Please ask for: Simon Algar  
Tel No: 01795 417375  
Our Ref: 18-506440-PAMEET  
Your Ref: -  
Date: 5<sup>th</sup> February 2019

**18/506440/PAMEET - Request for Pre-application planning advice - Derbies Barn, Stalisfield Road, Stalisfield - Proposed amendments to approved applications: Ref SW/01/0383 and SW/01/0384.**

Ground Floor Layout Plan
scale 1:100 @ A1

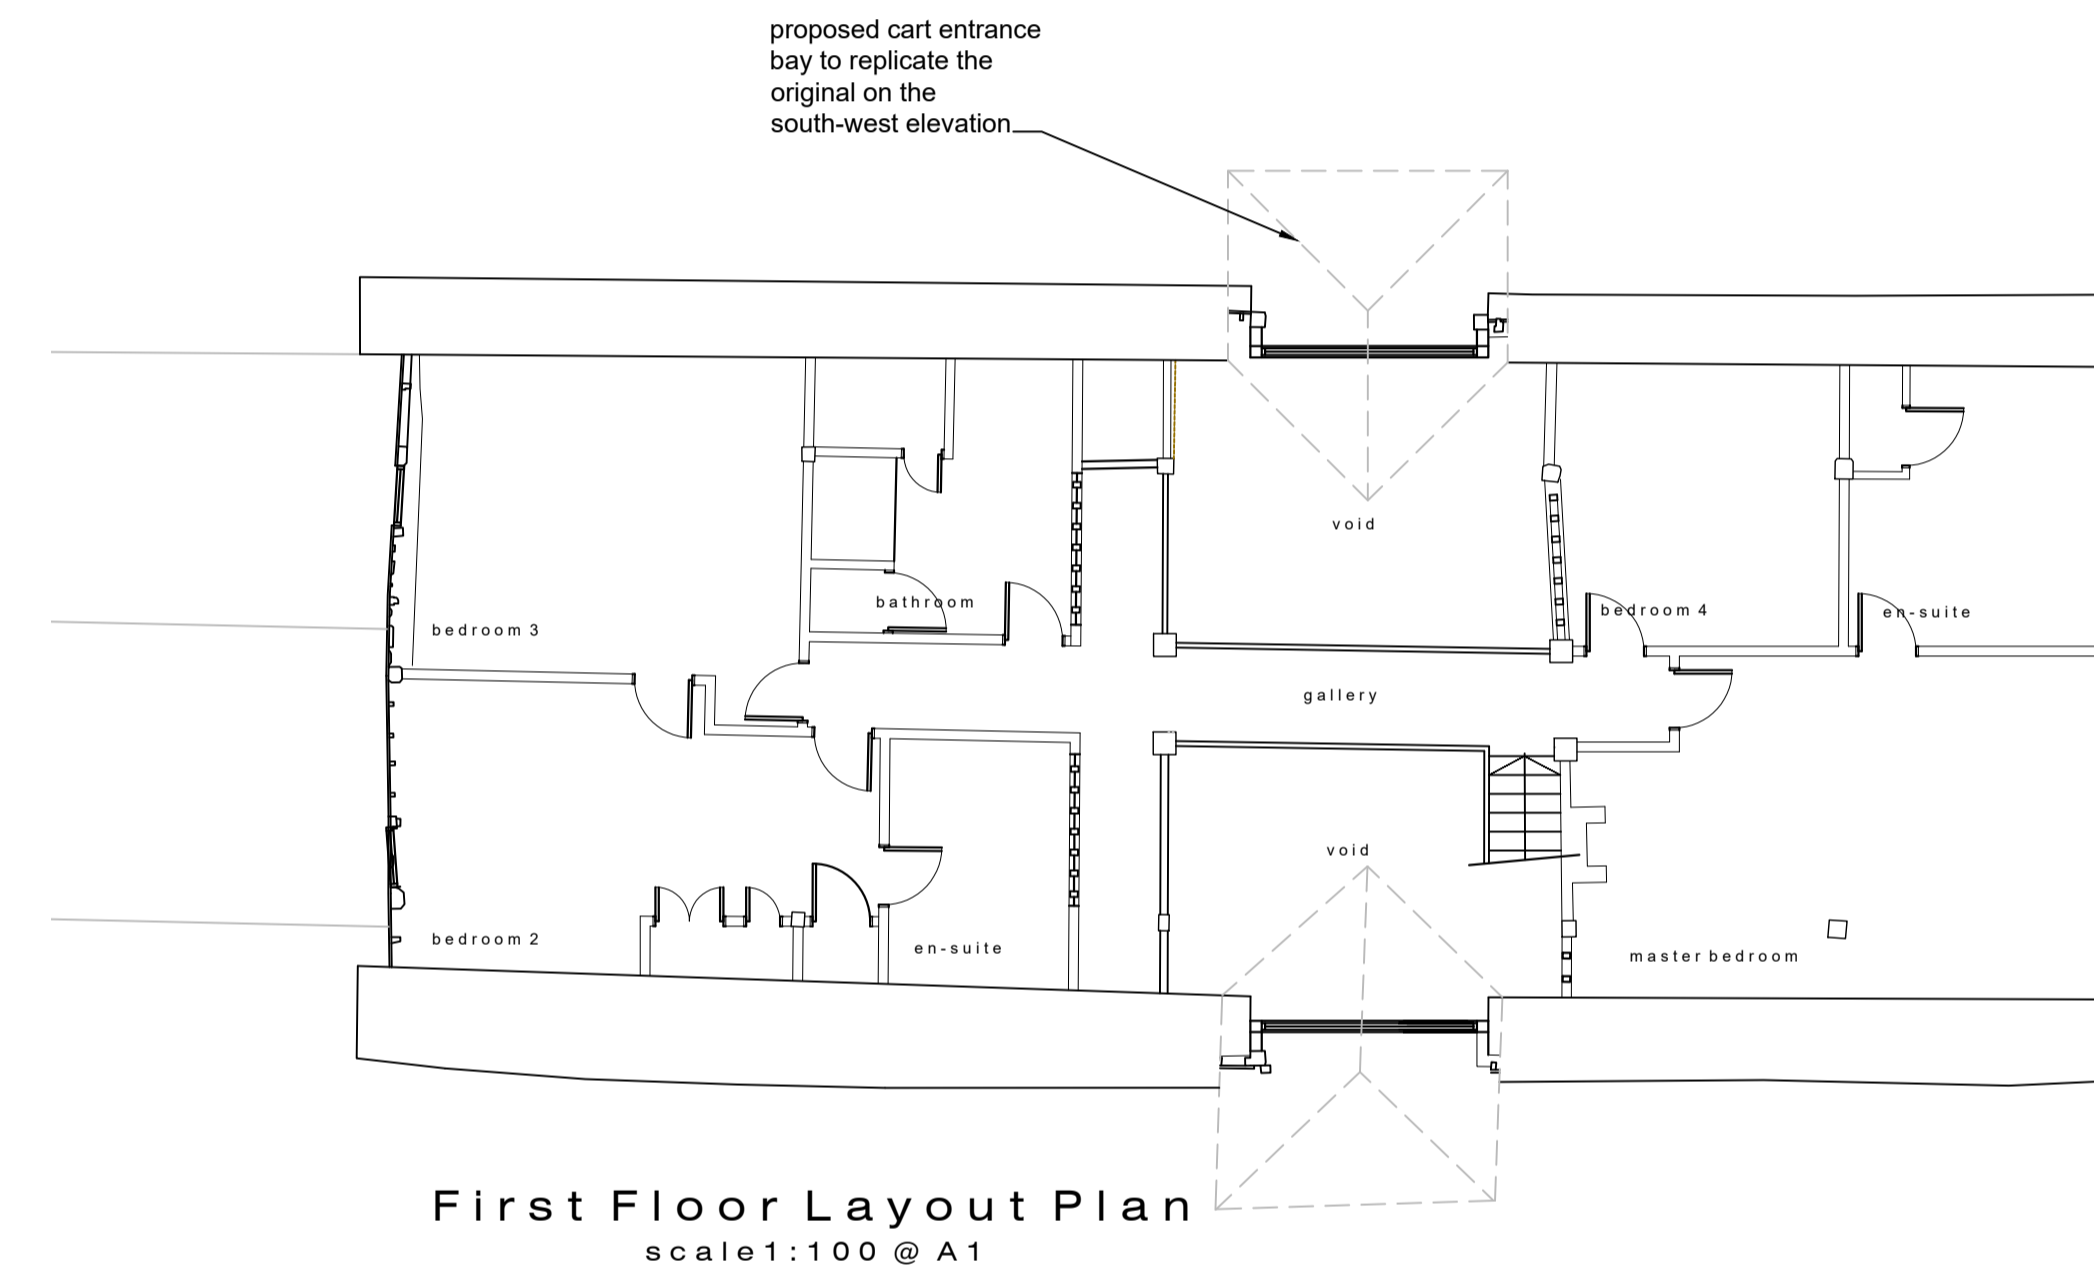
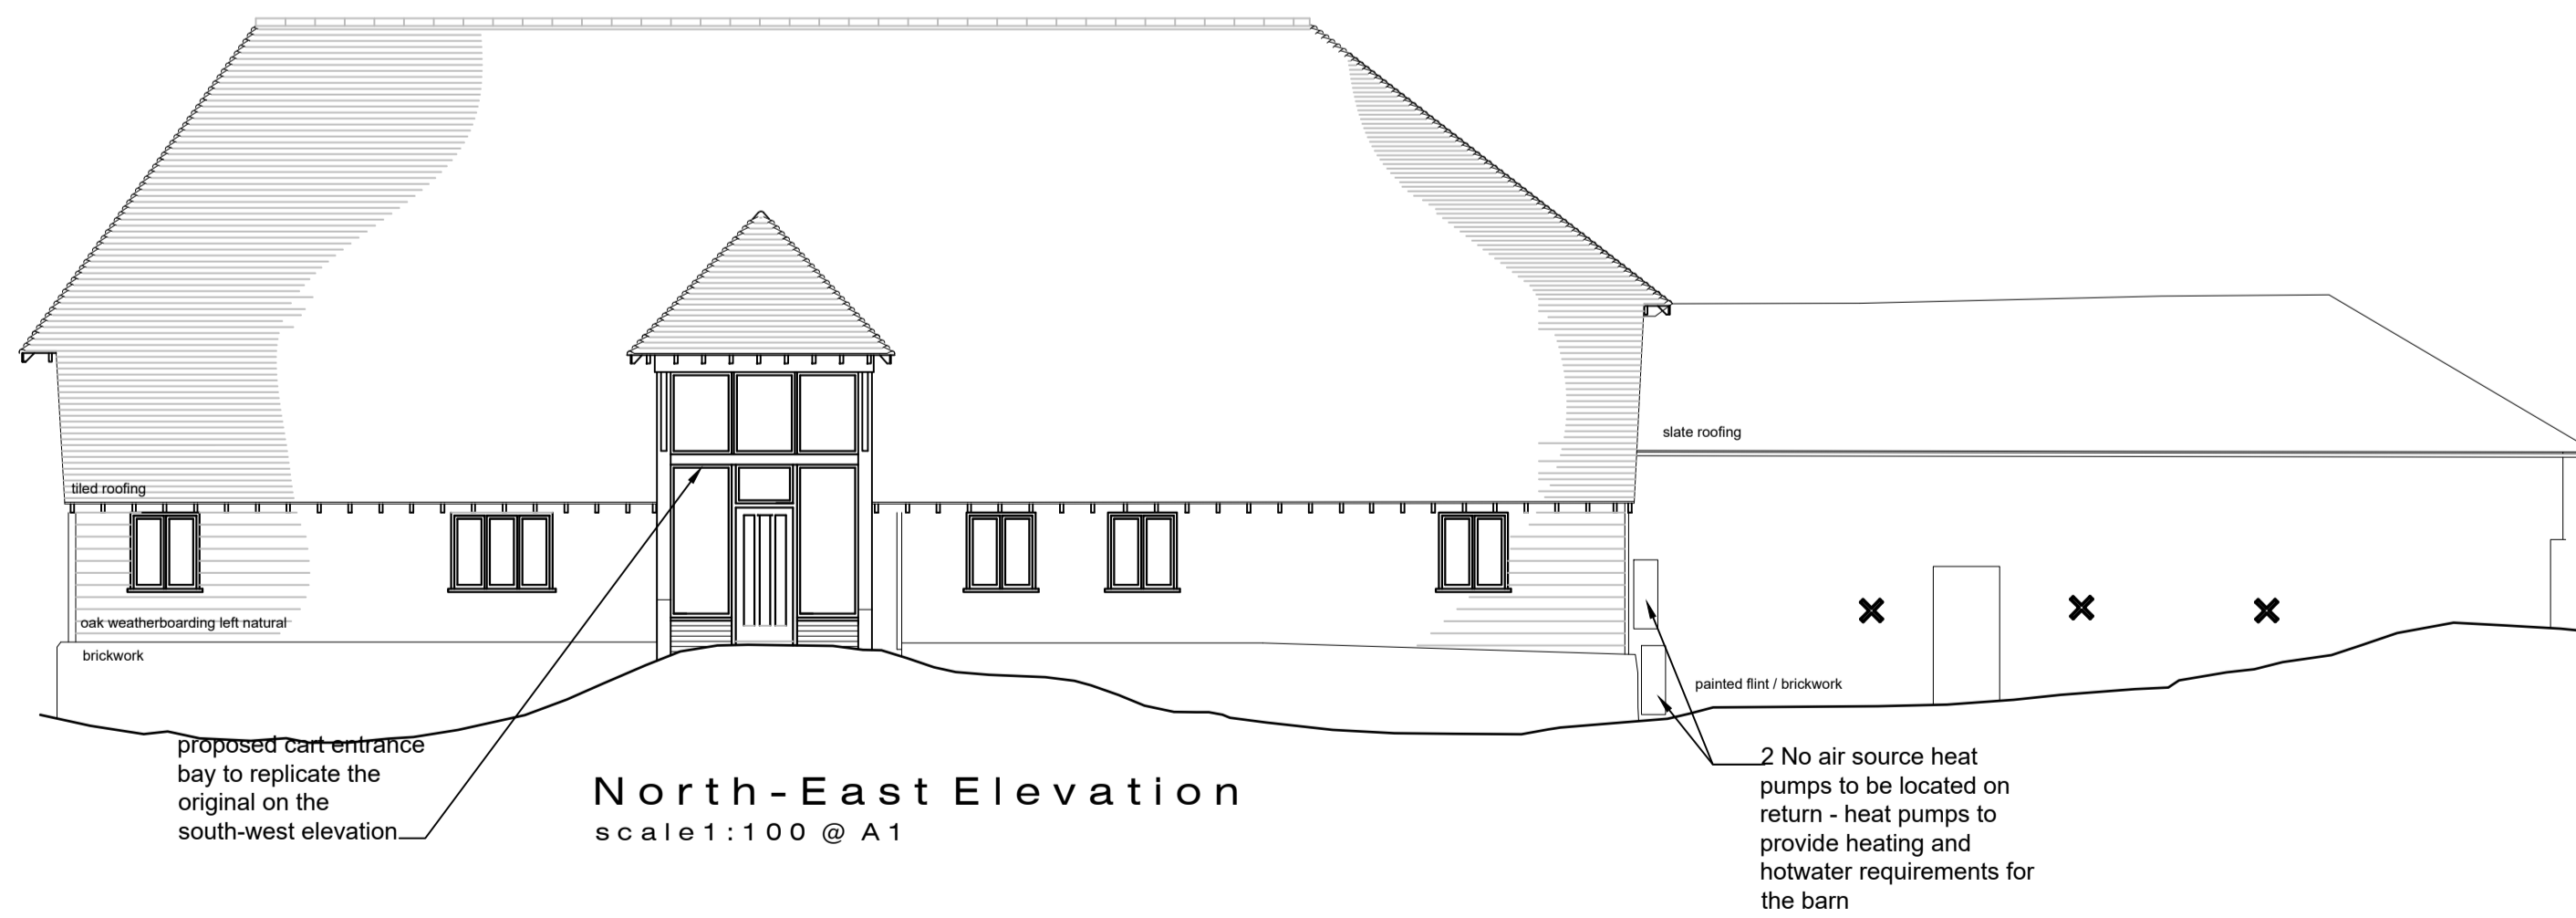
For the avoidance of doubt, I would confirm that the roof (as with the previous approved scheme) would need to be altered above the level of the purlins and tie beams to rise to a ridge, as would originally have been the case, prior to the truncated form we see today. Details of how this would be effected must be shown clearly on drawings for any revised scheme.

We touched on the issue of the roofing material for the adjacent outbuilding and I can confirm that if the main barn is to be re-roofed in Kent Peg tiles, then this smaller outbuilding should also be re-roofed in the same manner. Please note for your information (in case you weren't already aware) that this little building is listed in its own right (see list entry number 1069203 on the National Heritage List for England) and was originally constructed as a granary, hence its raised ground floor level on the staddle stones.

forward in the form of timber studs set back behind the line of the existing corner and central support posts and their associated brackets. Double glazed panels could be inserted between the studs, and these and the associated glazing would need to sit on a shallow red brick and flint work plinth to match that in use at the far north western end of this single storey addition to the main barn. You would also need to demonstrate in the planning application that there is sufficient car parking and turning space for at least 2 cars.

As discussed, the existing design in this respect was carefully considered at the time and represents a design approach broadly in keeping with the Borough Council's adopted supplementary planning guidance on the Conservation of Traditional Farm Buildings (see: <https://www.swale.gov.uk/assets/Planning-Forms-and-Leaflets/ConservationOfTraditionalFarmBuildings-feb-2011.pdf>). Your suggestion to alter this by effectively placing sheets/panels of glass of varying sizes in front of the studs is unlikely to be acceptable as a wholesale replacement design approach, but if you remain wedded to this idea, favourable consideration could possibly be given to the use of this approach as a feature wall in the relatively discrete location of the northernmost bay of the barn on the rear, NE facing elevation. This would be in lieu of some of the existing weatherboarding to this wall plane, and I would suggest that the panel of glass would need to be fixed to an external dark stained timber frame butted up against a section of weatherboarding at either end and fixed to the sole plate and wall plate using colour-matched wedges, if necessary to ensure that a true vertical plane could be achieved. I would suggest that non-reflective glass should be used for this proposed feature, and should you wish to pursue this idea further, it would need to be presented as part of a revised set of application proposals (along with the aforementioned proposed changes), and supported appropriately by a large scale part elevation and sectional drawing prepared by a conservation architect.

As discussed, it is not clear why the ground levels are raised as they are towards the door opening on the elevation in question but it may well serve a structural purpose rather than, or possibly in addition to, a practical purpose providing a base on which to step down from the barn onto, and vice versa. My recommendation is that the mounding is not removed but improved to provide a safer and more level access platform without making it look like a heavily engineered structure. Should you wish to remove the mounding and replace it with a simple, dark-stained set of wooden steps and landing platform with associated posts and handrails, then I would advise this would need to be shown in drawings as part of any revised scheme, and supported by a conservation accredited structural engineer's report advising on the potential structural implications for the building arising from this proposed change. The report would need to be informed by some limited test pits dug carefully at the junction between the wall plane and the earth mounding.
